## BULLETIN No. 3

Date: February 5, 2013  
To: Allied Cook  
RE: TSL Building - Showroom and Service Bay Additions  
Portland, Maine  
JHN #: 2008-279.3

1
A101
FLOOR PLAN
SCALE: 1/8" = 1'-0"

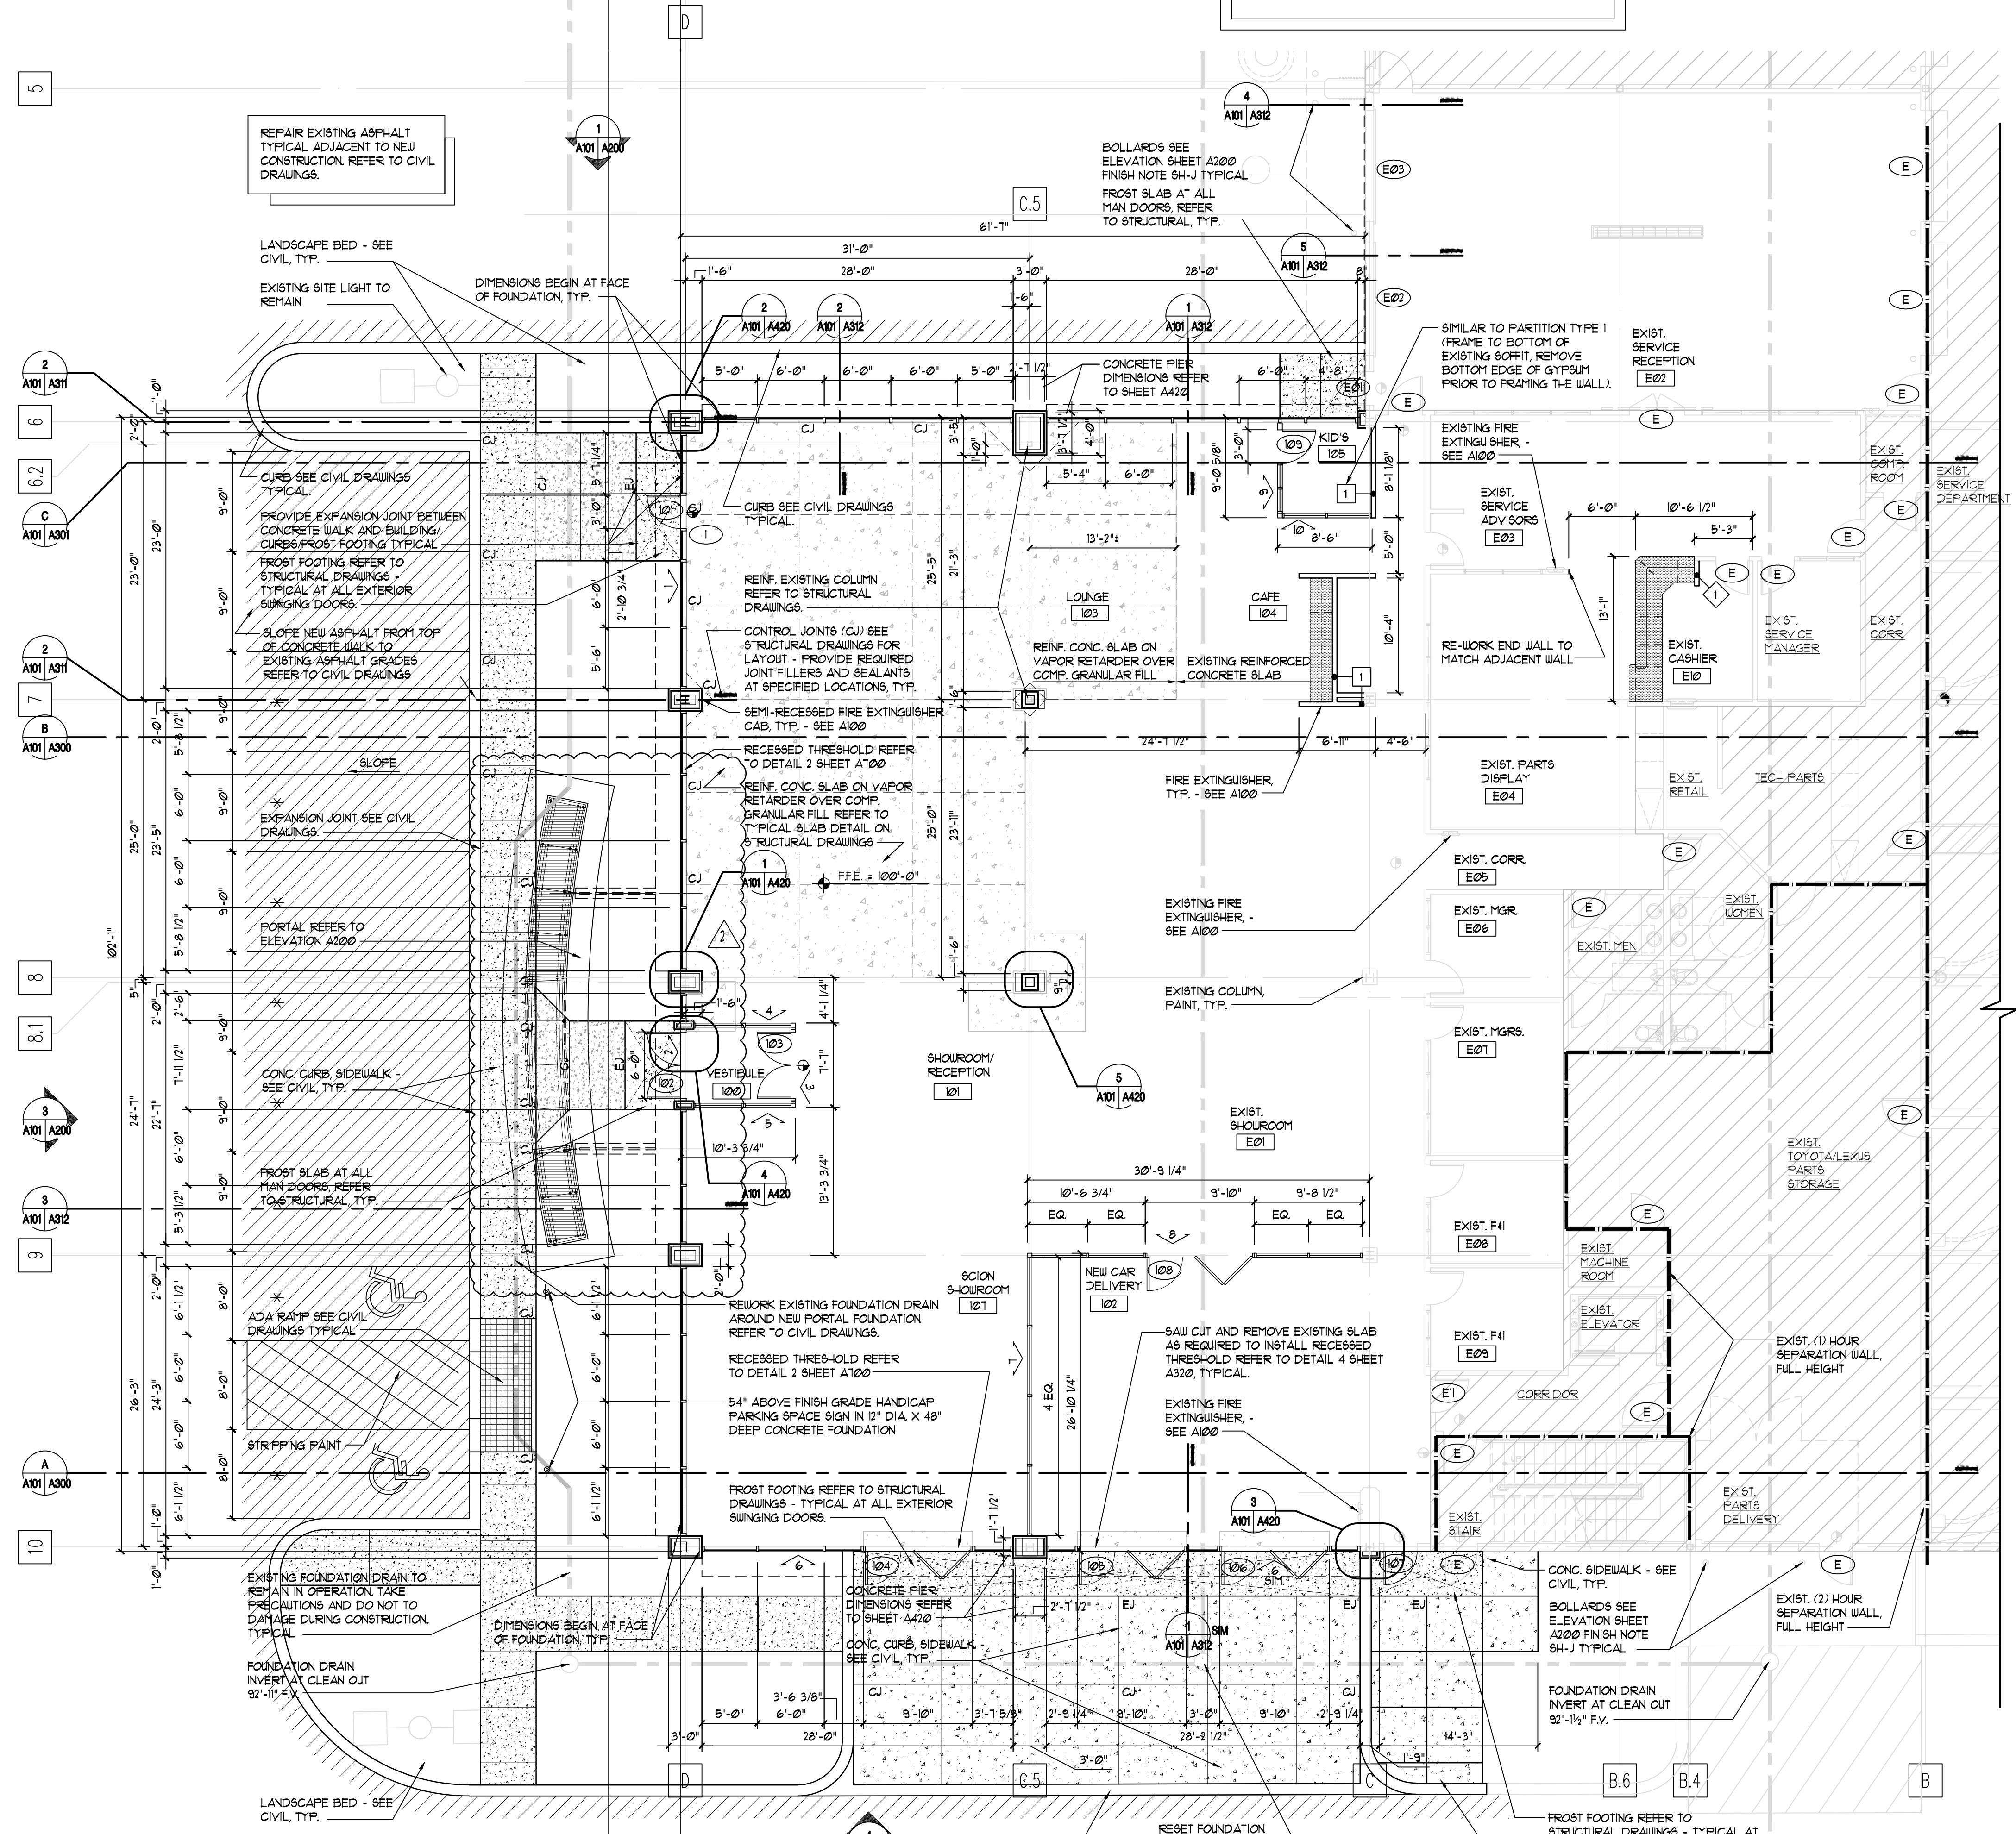
Item 2.2 Refer to Sheets A101

- Updated layout and scope per interior designer scope of services
- Indicated refer to Impresa Unlimited for all millwork information

A310

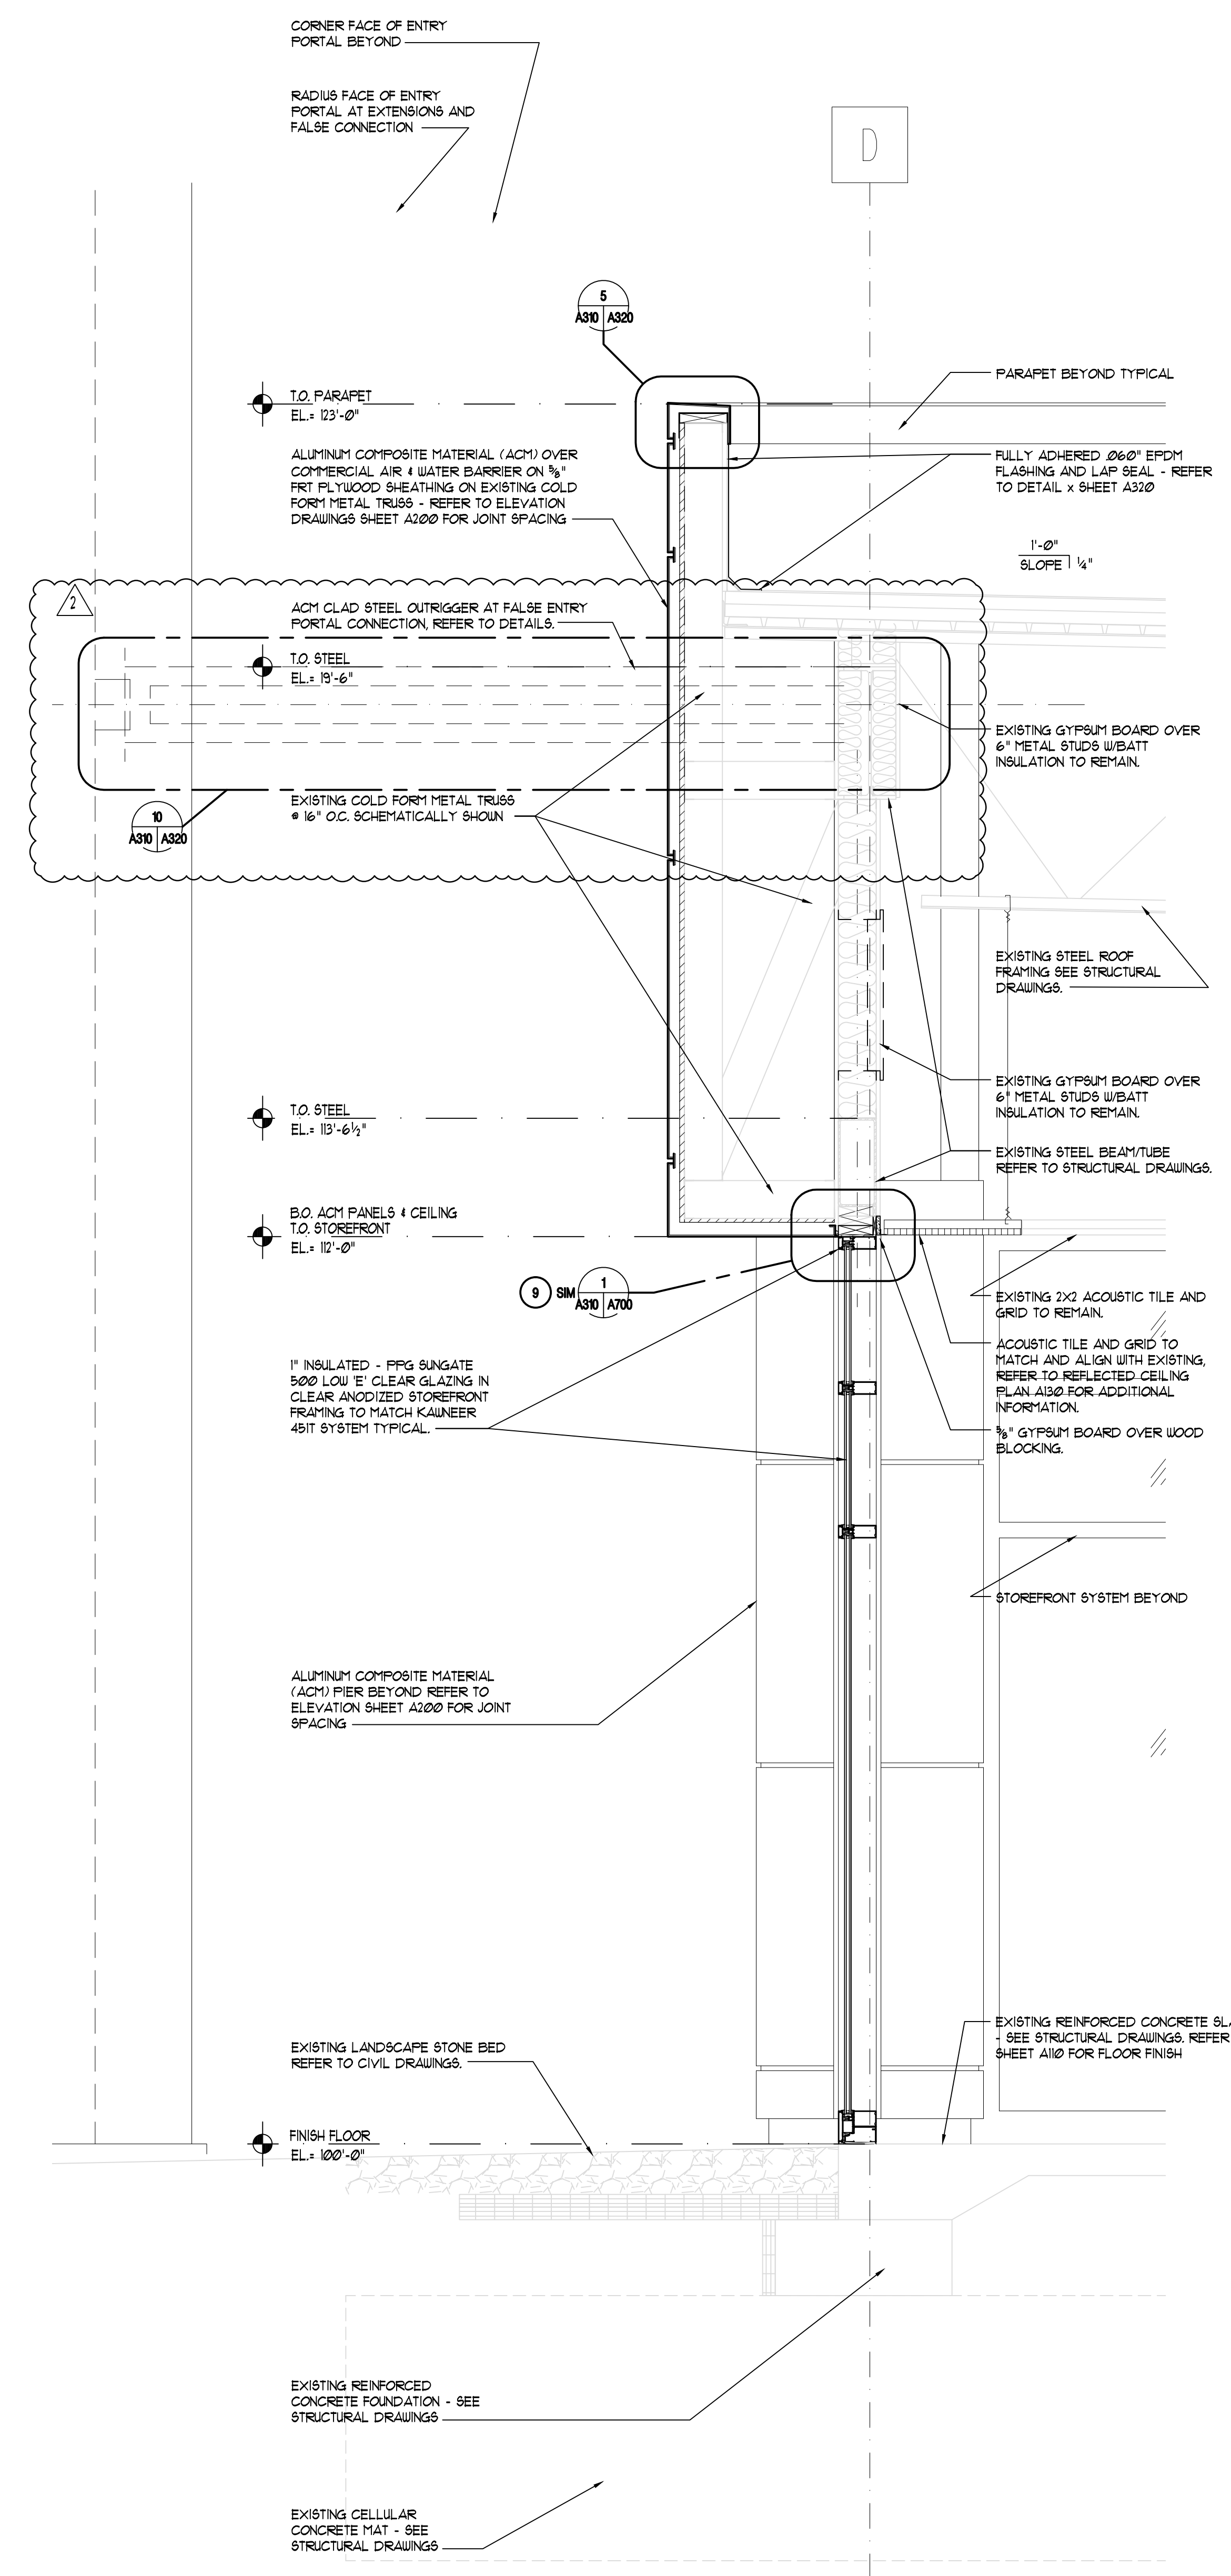
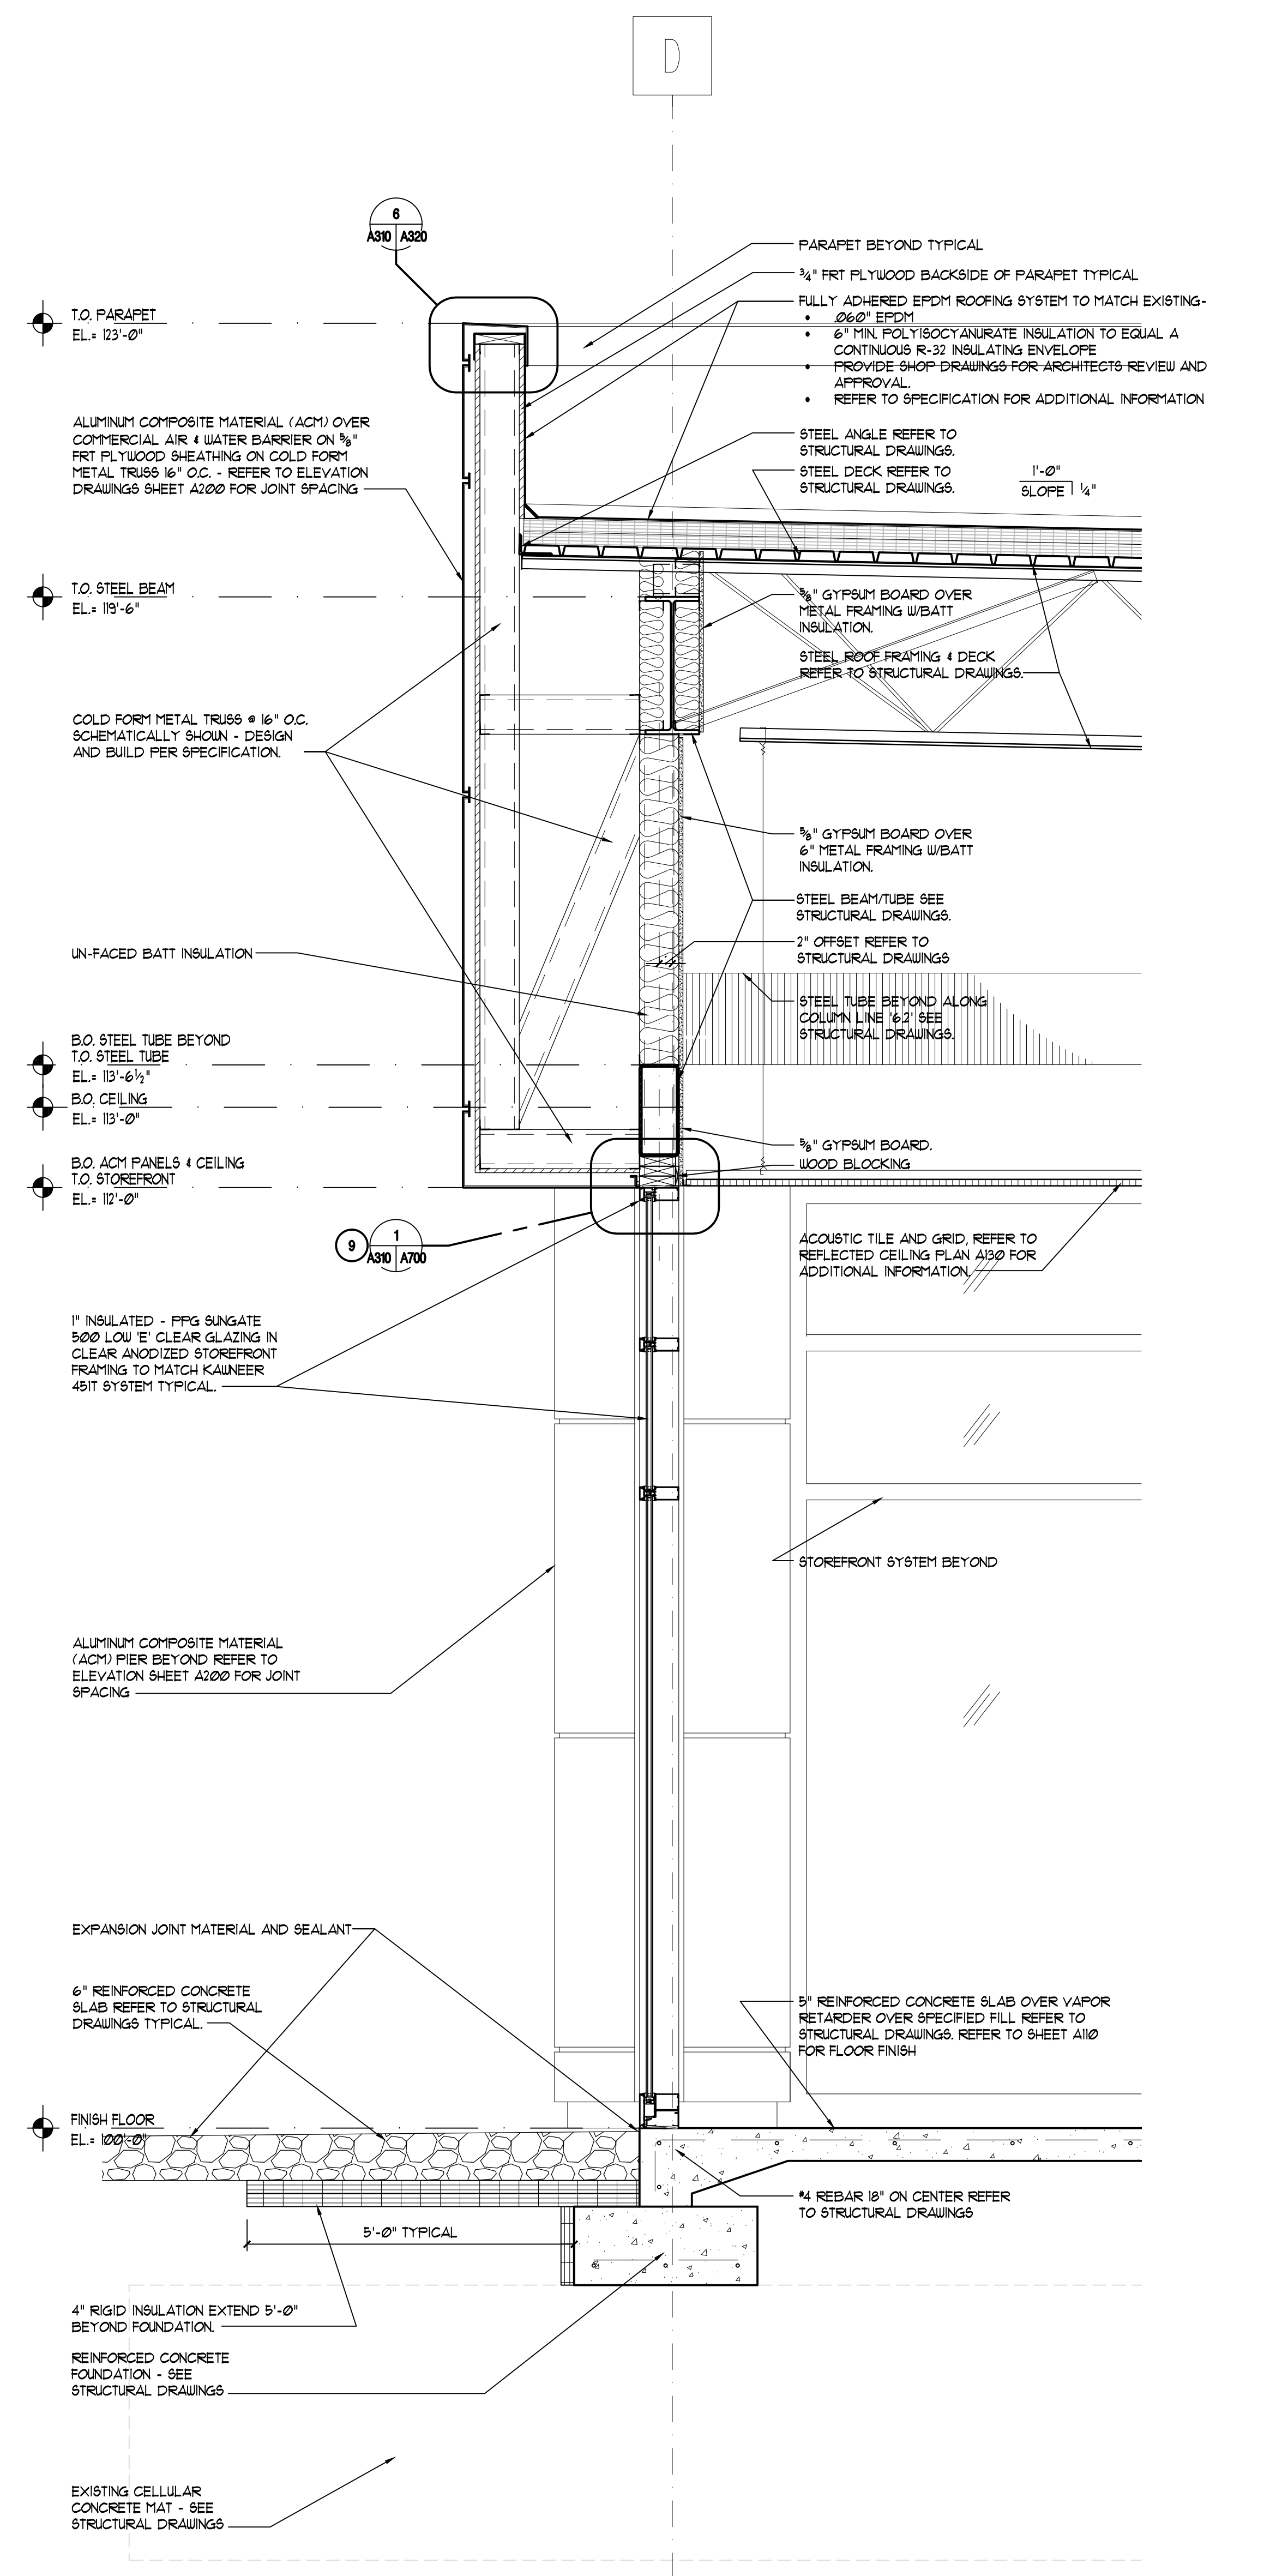
Item 2.5 Refer to Sheets A300, A301, A311, A320

- *Revised sections based on new configuration, walls etc.*
